RESPONSE TO SUBMISSIONS: PROPOSED MANUFACTURING FACILITY AND ASSOCIATED WAREHOUSE

657-769 MAMRE ROAD, KEMPS CREEK
LOT 10 APPROVED UNDER SSD 9522

18 August 2022

SSD-25725029

RETAINING WALL TYPE 2
(REINFORCED EARTH WALL)
SCALE 1:20

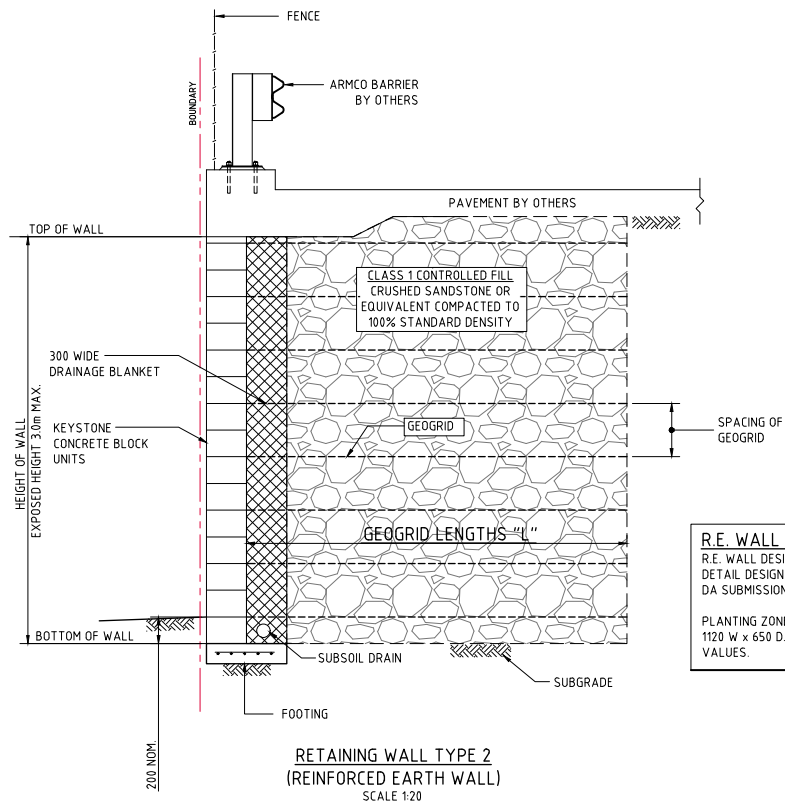
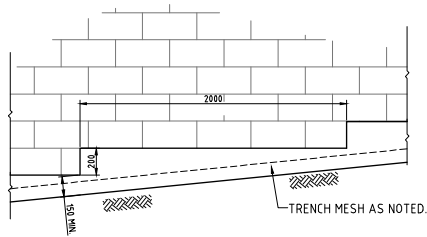
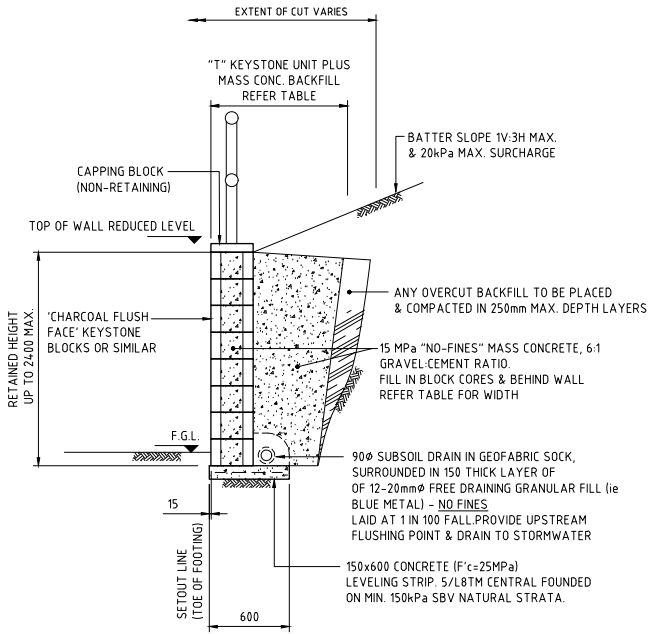
SUBMITTER	MATTERS RAISED	COMMENTS / REQUESTS	FORMAL RESPONSE
		The Civil Report indicates that several retaining walls are proposed. These are not discussed / considered in the EIS. The Department requires that this detail is included in the RtS.	<p>Details of the proposed retaining walls, consistent with the details provided in the Civil Report, have been included in Table 24 of the EIS.</p> <p>The amended Civil Report provided in Appendix C3 of this RTS has been updated to include typical wall details. Low height retaining walls are proposed as shown in the Appendix C2. Walls are noted to boundary and locally around garden beds. Walls fronting public domain are less than 1.2m in height and have been setback from the boundary in accordance with the MRP DCP.</p>
		The Civil Report references 'this Mod 1 Application'. It is unclear if this reference is in relation to SSD-9522-Mod 1. Please update the Civil Report as relevant.	The amended Civil Report provided in Appendix C3 of this RTS has been updated to remove references to 'this Mod 1 Application'.
